Case ref. EN010116 - Interested Party No. 20032332.

Deadline 8 Submission comments on Volume 6 Environmental Statement 6.2.5 Air Quality.

Title Figure 4
NO₂ 1 Hour
Maximum
Contours

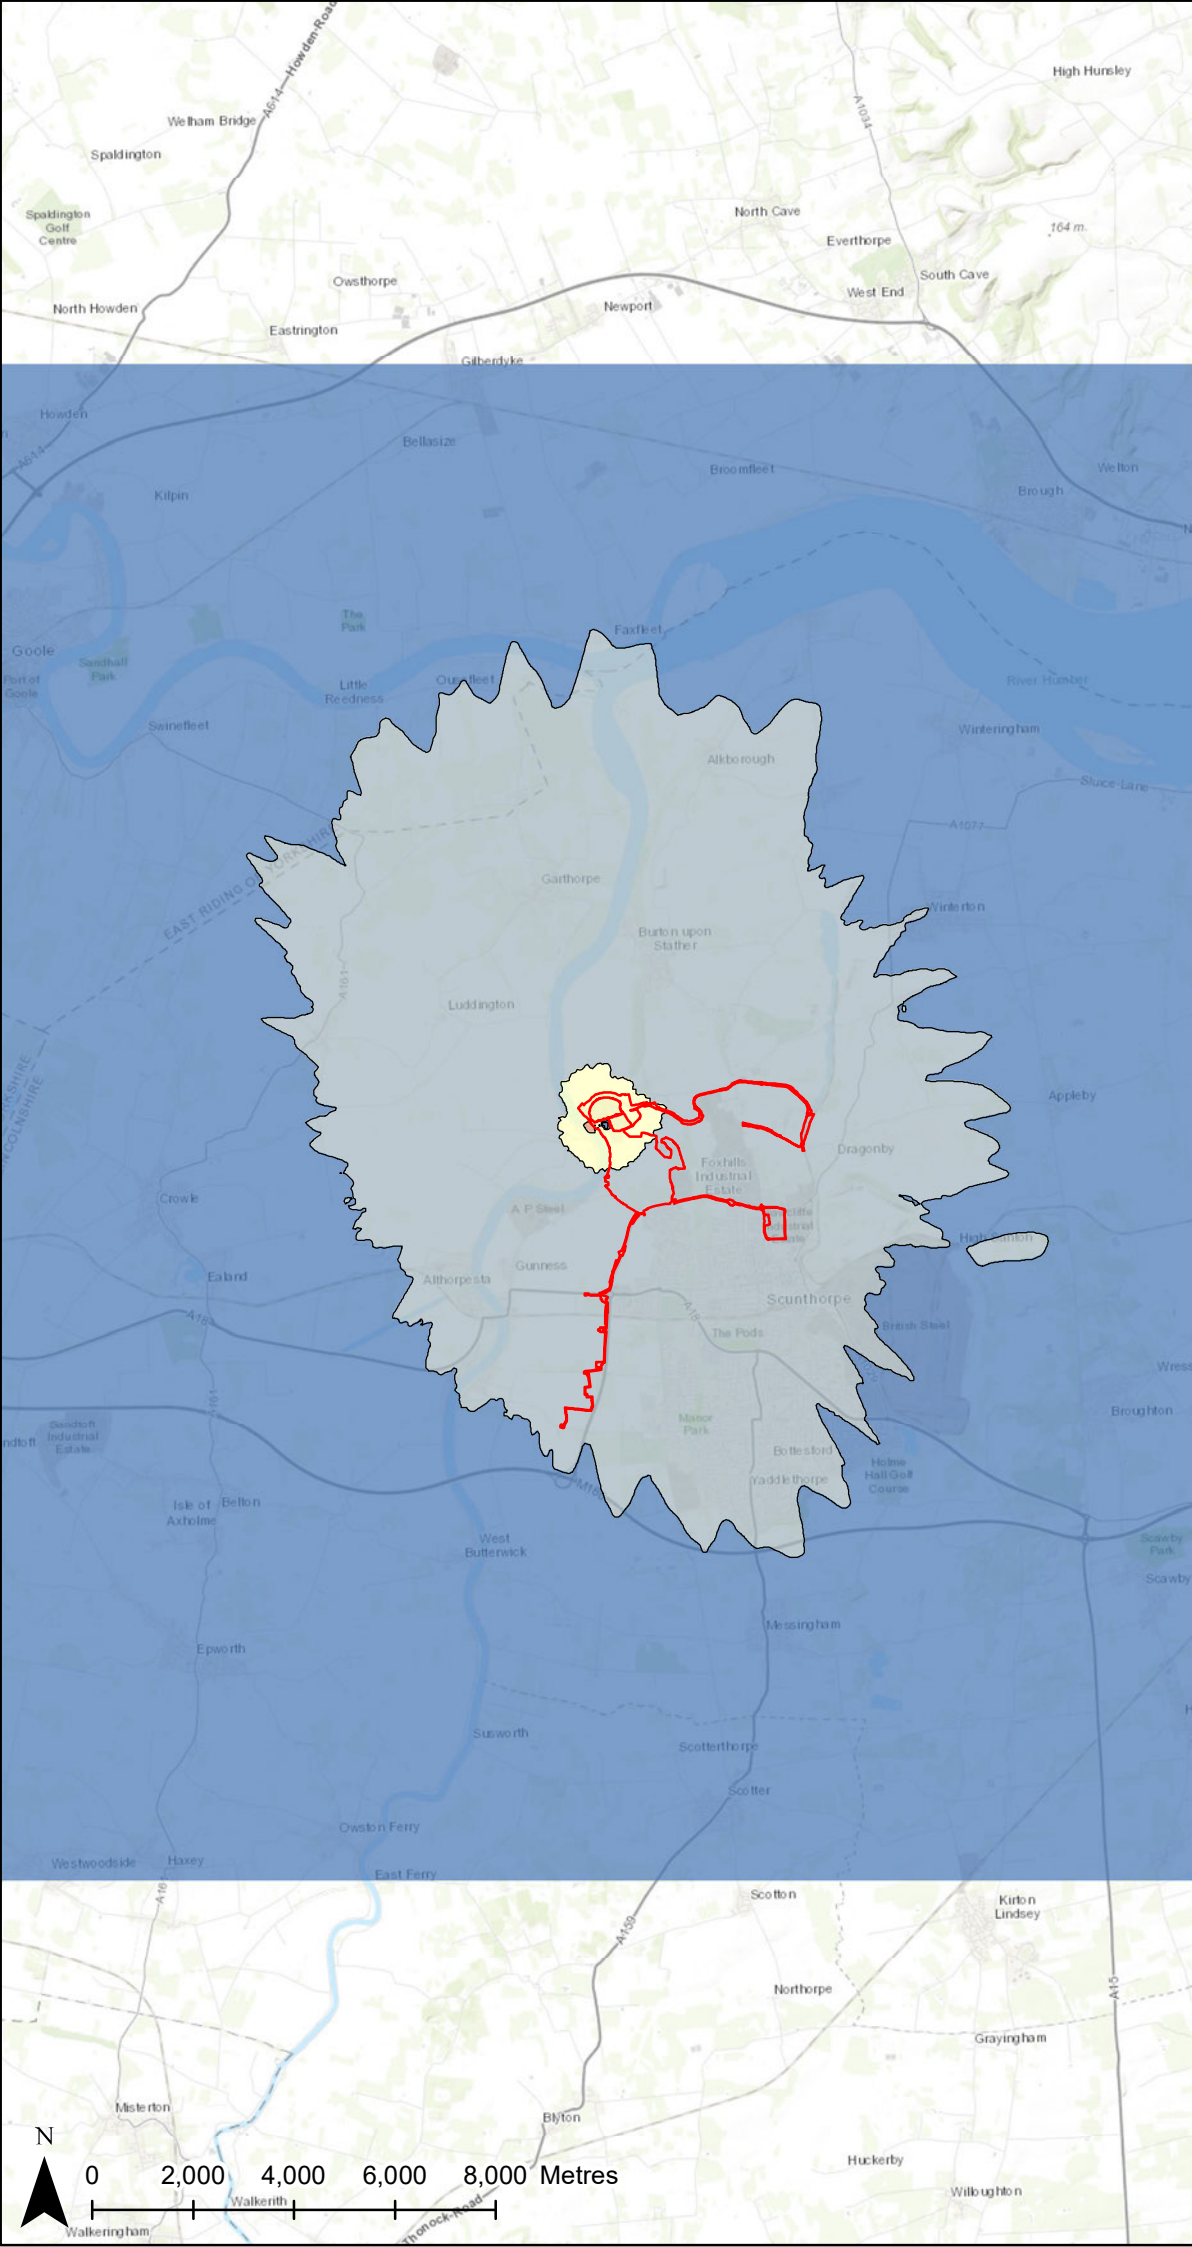
Would the applicant like to explain why they have used British National Grid maps, as used for planning purposes, and omitted the names of both Amcotts and Flixborough from those maps on figures 4,5,6,7, and 8, pages 102 to 106 in Appendix A.

AMCOTTS in particular because of its CLOSE PROXIMITY to the proposed development will be a crucial receptor impacted by NO₂, NO_x and PM₁₀, yet has astonishingly, along Flixborough, been erased from these images.

Can the applicant explain why villages that will apparently be impacted less by the pollutants ARE shown on these same images.

How can information of such crucial importance be left out? Is it to give the general impression that we don't exist or that there are no nearby villages that will be impacted by pollutants from the proposed development?

Furthermore with reference to the same figures 4,5,6,7 and 8 pages 102 to 106 Appendix A, can the applicant explain why, as well as the two village names being omitted, they have also omitted the yellow squares indicating "Human Receptor" with regard to pollutants NO₂, NO_x and PM₁₀ in those UNIDENTIFIED village areas?
